Application by Oaklands Farm Solar Limited for an Order Granting Development Consent for Oaklands Farm Solar Park
The Examining Authority's third written questions and requests for information
Issued on Tuesday 12 November 2024

The following table sets out the Examining Authority's (ExA's) third set of written questions and requests for information (ExQ3).

Figure 1c: Habitat constraints plan

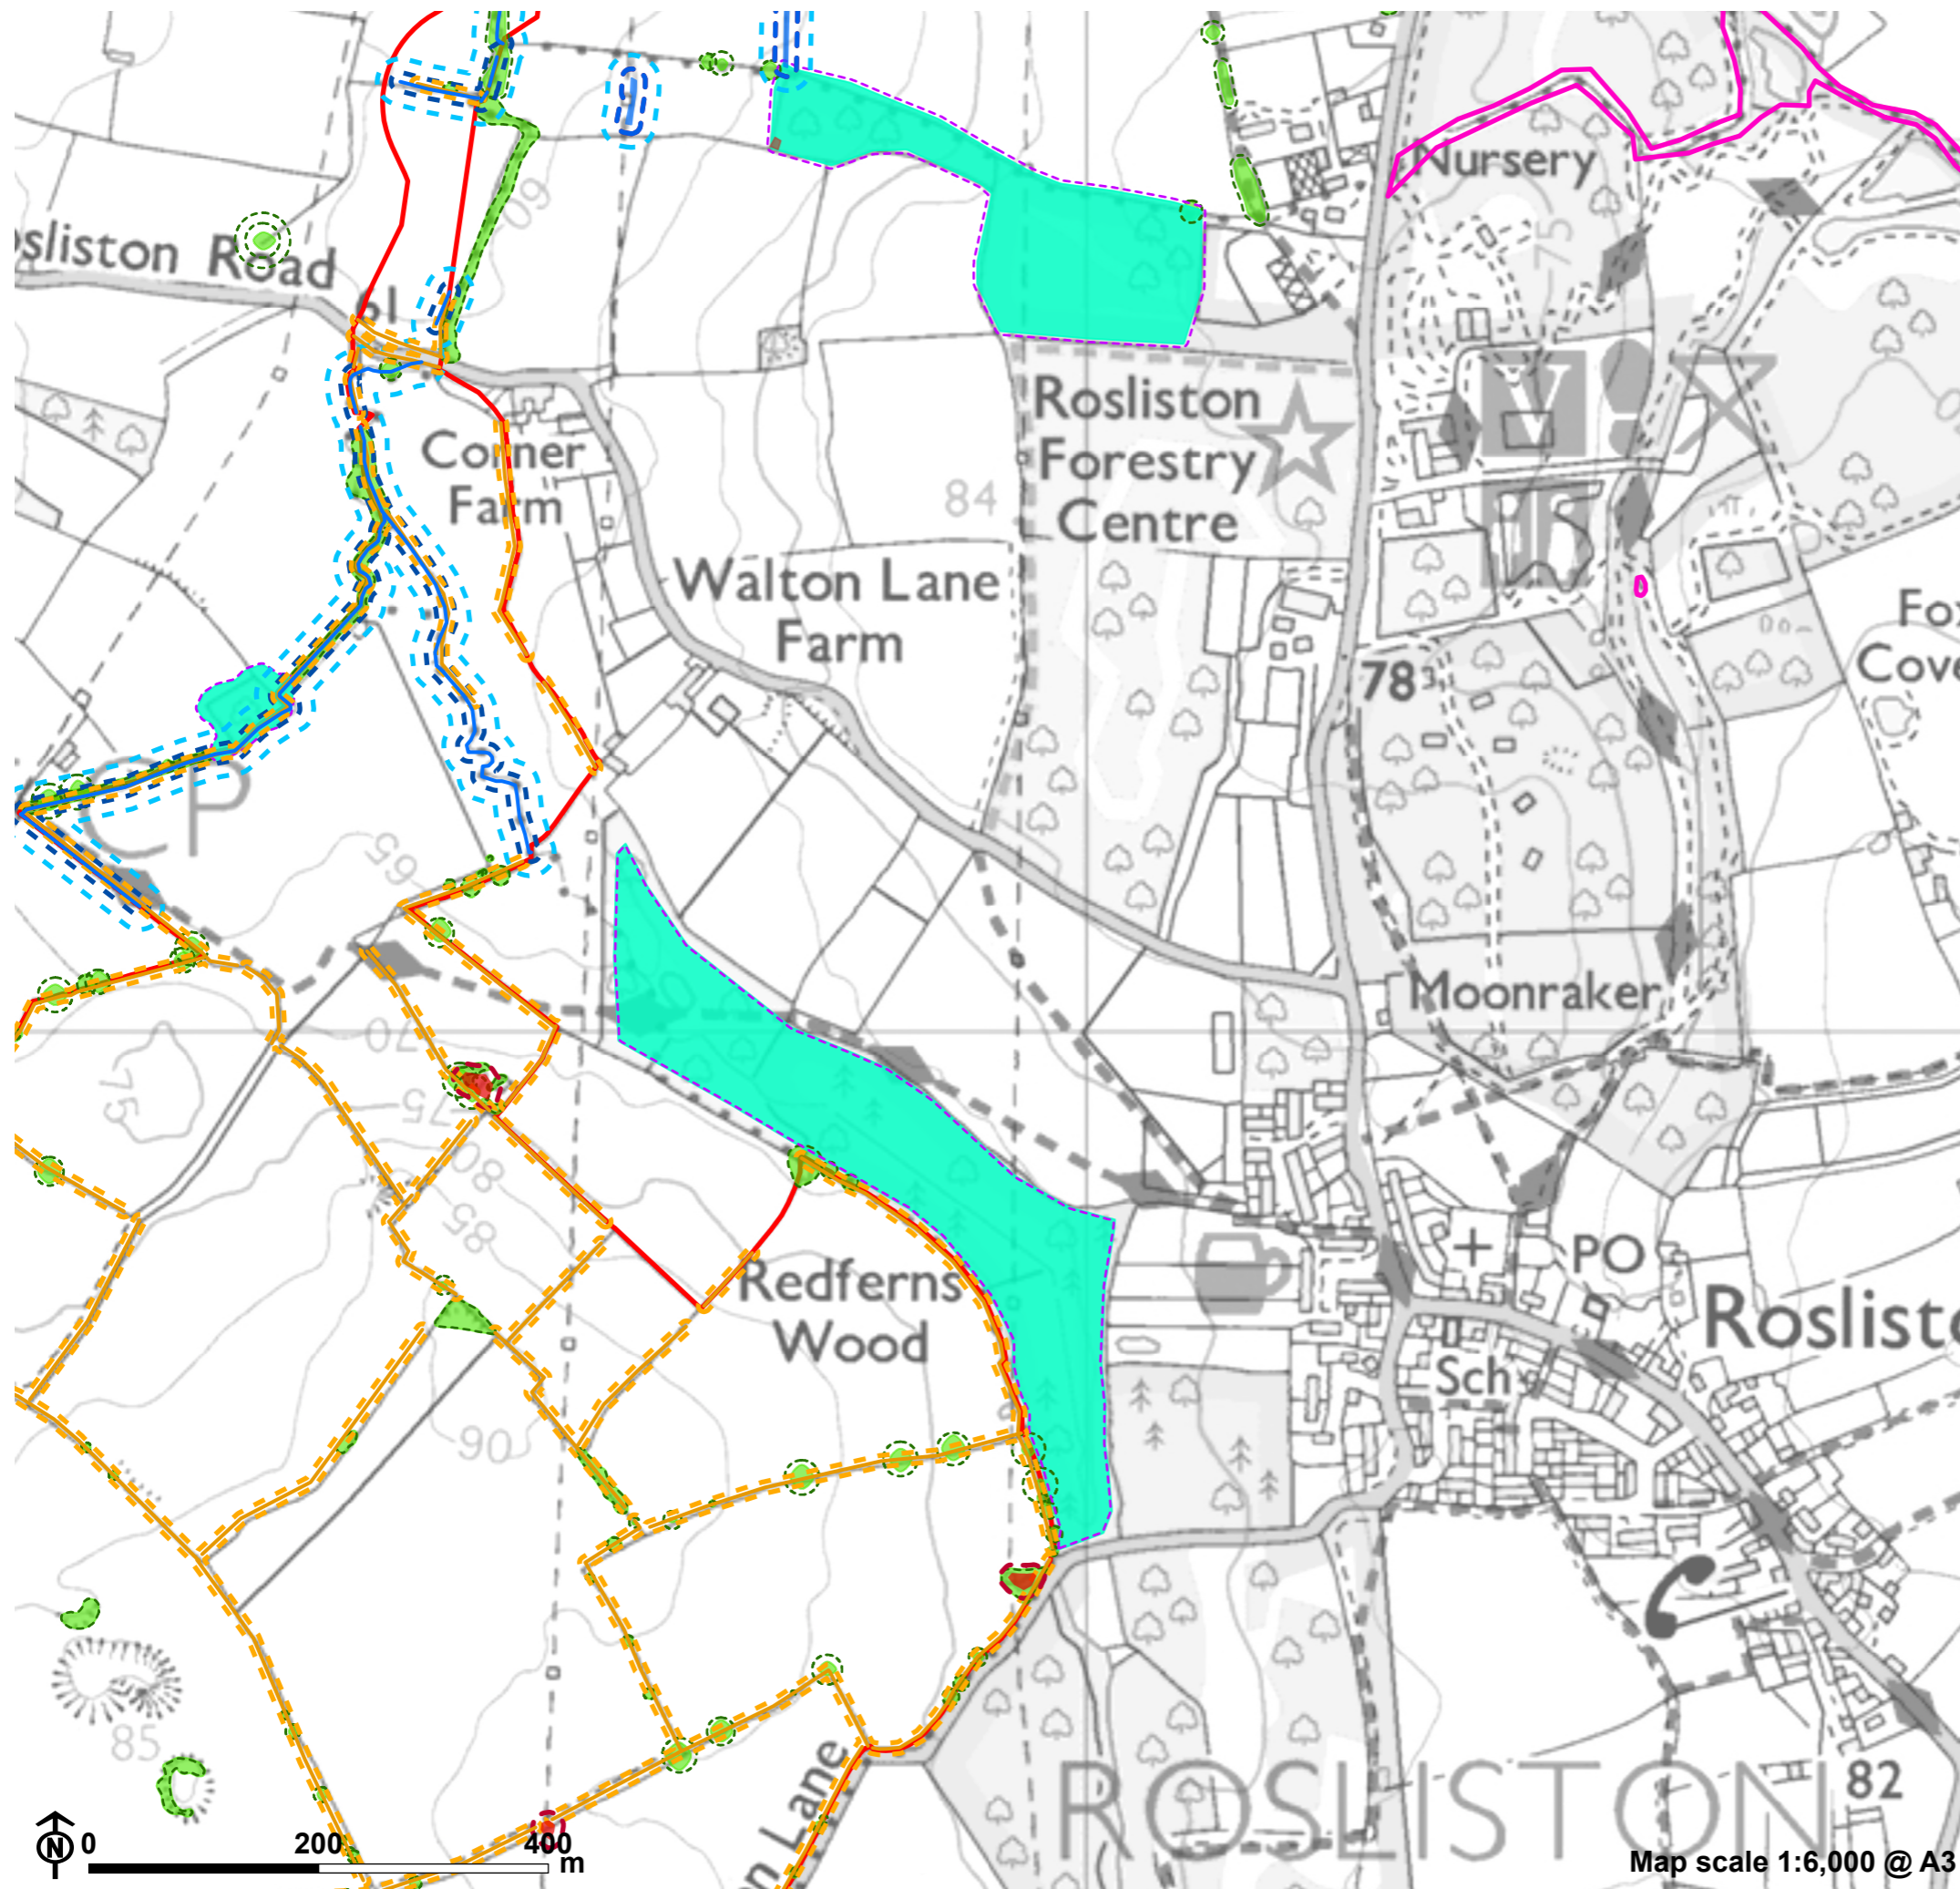
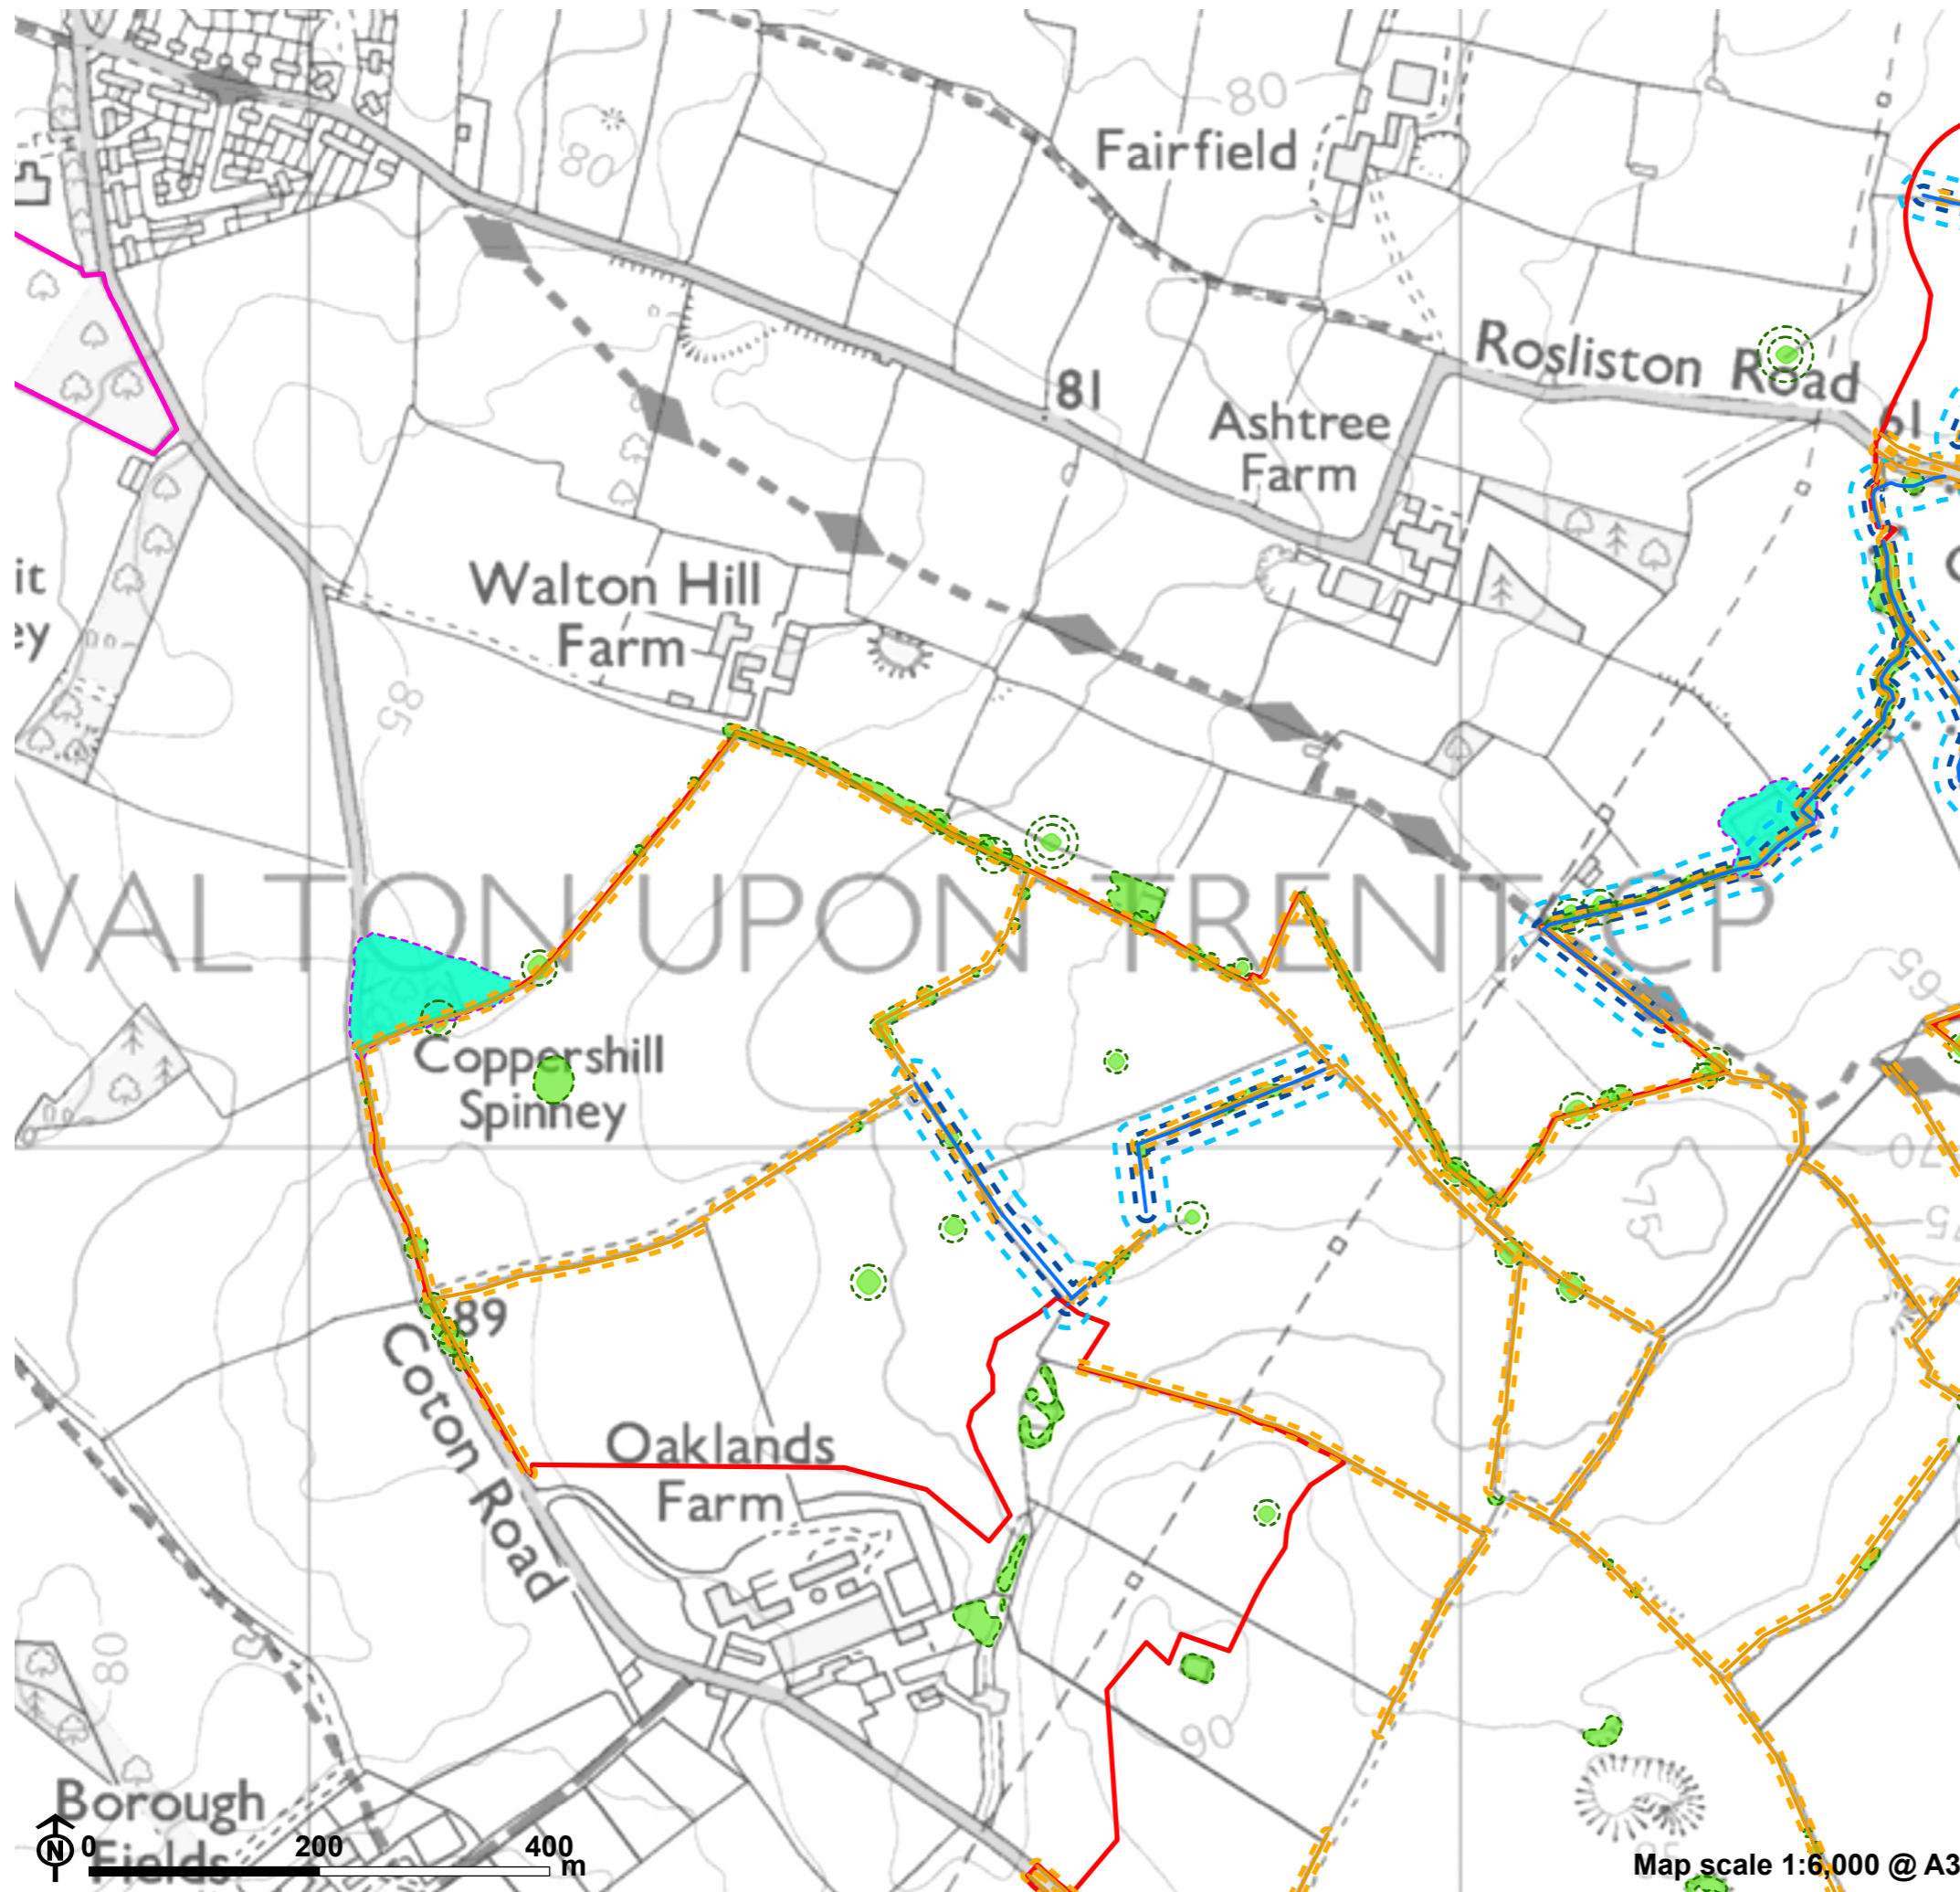
| Ref: | Question to: | Question: |
|------|--------------------------|---|
| 7.3 | Applicant SDDC DCC | <p><u>Habitat Constraints Plan</u></p> <p>SDDC [REP4-014] and DCC [REP4-012] referred to the need for a Habitat Constraints Plan with interpretable maps to provide the necessary details and extent of site clearance works relating to buffer zones to sensitive features such as ancient/ veteran trees, other retained trees, ponds, watercourses, hedgerows and woodlands.</p> <p>The Outline CEMP [REP5-011] includes provisions for a Habitats Constraint Plan [Section 2.8.5] and buffers [Sections 2.6.4, 2.6.5, 2.8.2, 2.8.3, 2.8.5, and 2.8.6]. The Applicant provides a series of interpretable maps of habitat constraints [REP5-030].</p> <ul style="list-style-type: none"> a) Please could the Applicant add the draft interpretable maps to the Outline CEMP [REP5-011] and secure that interpretable maps be included in the final CEMP? b) Please could SDDC and DCC comment? c) Please could SDDC and DCC also summarise any outstanding concerns at Deadlines 7 and 8 with suggestions about how they might be addressed? |
